Report of the Head of Planning, Transportation and Regeneration

Address 31 ST EDMUNDS AVENUE RUISLIP

Development: Demolition of existing garage and erection of outbuilding including a decking area to rear garden (Application for a Certificate of Lawful Development for an Existing Development)

LBH Ref Nos: **58245/APP/2021/4066**

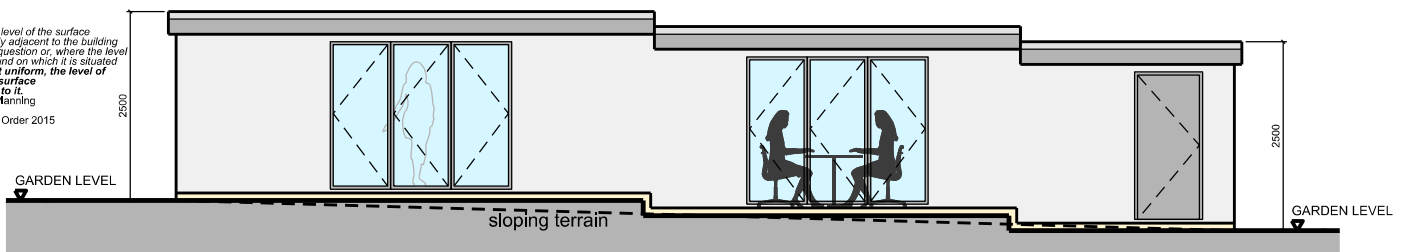
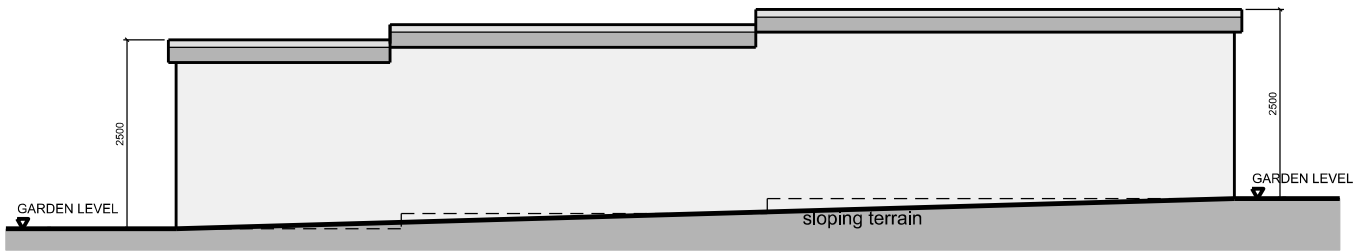
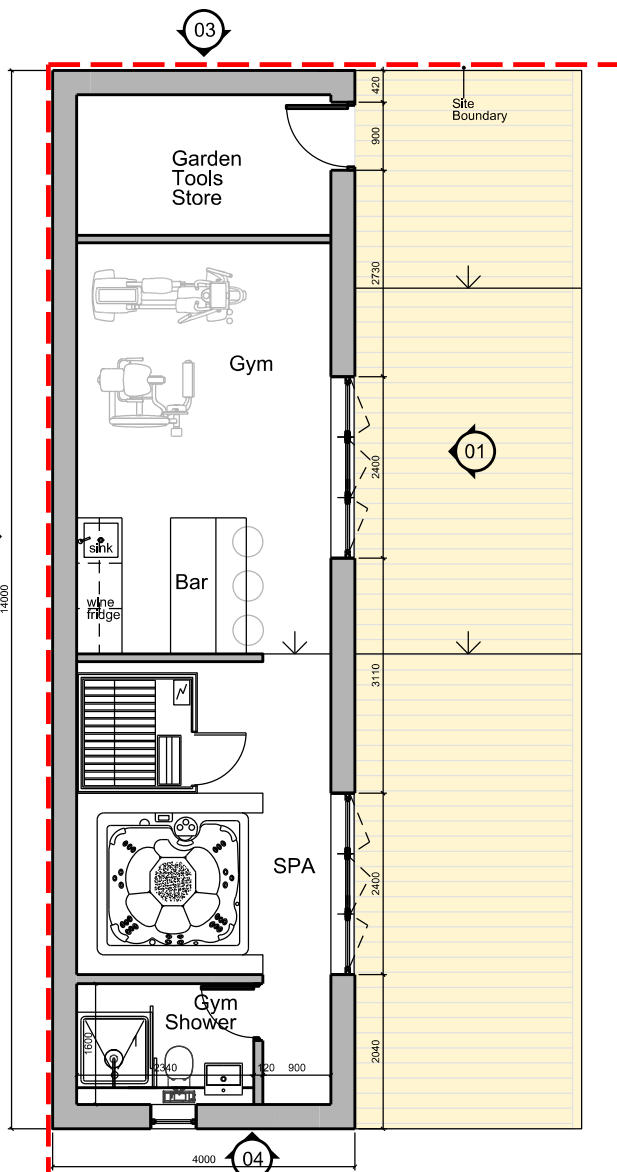
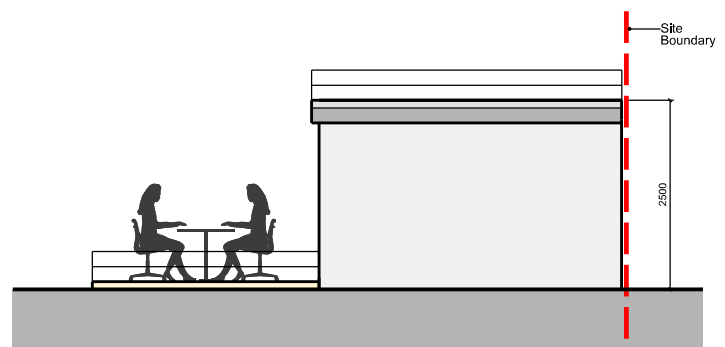
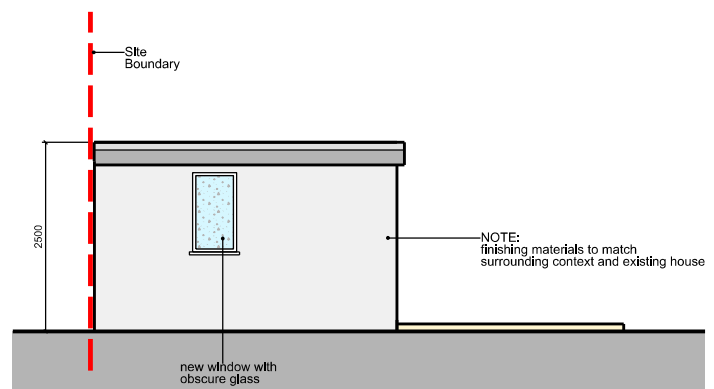
In this case, the constructed outbuilding measures approximately 14 metres in length and 4 metres in depth. It has a footprint of approximately 56 square metres, which equates to 65% of the original ground floor footprint of the host property. As such, it is considered that the size of the outbuilding is not commensurate to the size of the dwellinghouse. Notwithstanding this, it is noted that the size of an outbuilding is not, in itself, determinative of whether a development falls within the provision of Class E. It is also necessary to look at the function of the space within the outbuilding and determine whether the outbuilding is reasonably required for a purpose incidental to the enjoyment of the dwelling.

In this case, the submitted plans show that the outbuilding contains a spa, bar/gym (including a kitchenette) and a garden tools store. However, no details have been provided to explain why such facilities are required in connection with the host dwelling. The burden of proof rests with the applicant and the appropriate test of evidence is the balance of probabilities. In this particular case, apart from the labelling of the outbuilding for a variety of uses, no further information has been provided. Consequently, on the evidence available, it is considered, as a matter of fact and degree, that it has not been demonstrated that on the balance of probabilities the constructed outbuilding is reasonably required for purposes incidental to the enjoyment of the dwellinghouse.

In this case, the submitted drawings shows constructed outbuilding is positioned along mutual boundary shared with No. 33. The annotations on the drawings indicate that the outbuilding has a maximum height of 2.5 metres. However, it is not clear from the submitted drawings as to whether the existing ground level, is as a matter of fact and degree, the natural ground level of the site. From reviewing the notes and photographs submitted by the enforcement officer who conducted the original site visit, it is clear that the properties in this section of St. Edmunds Avenue have a natural decline from west to east. The officer site photographs (enforcement report) also shows that the ground levels at the site have been altered. There is therefore ambiguity in respect to the maximum height and eaves height of the constructed outbuilding in relation to the natural ground level of the site.

Having regard to the above, it is considered that the submitted information does not conclusively show that the outbuilding complies with provision E.1 (e)(ii) and (f), Class E, Part 2, Schedule 2 of the GPDO, in respect to its maximum height and eaves height.

The floor plan shows a decking area running across the full width of the constructed outbuilding. The submitted drawings indicate that this decking area has a height of 10 cm. However, as stated in the preceding paragraphs, it is unclear whether the ground level shown on the submitted drawings, is as a matter of fact and degree, the natural ground level of the site. It is therefore considered that insufficient evidence has been submitted to conclusively demonstrate that the decking area would not constitute as a raised platform.

As such, the decking area is not considered permitted by provision E.1 (h), Class E, Part 1, Schedule 2 of the GPDO and provision A.1 (k)(i), Class A, Part 1, Schedule 2 of the GPDO.
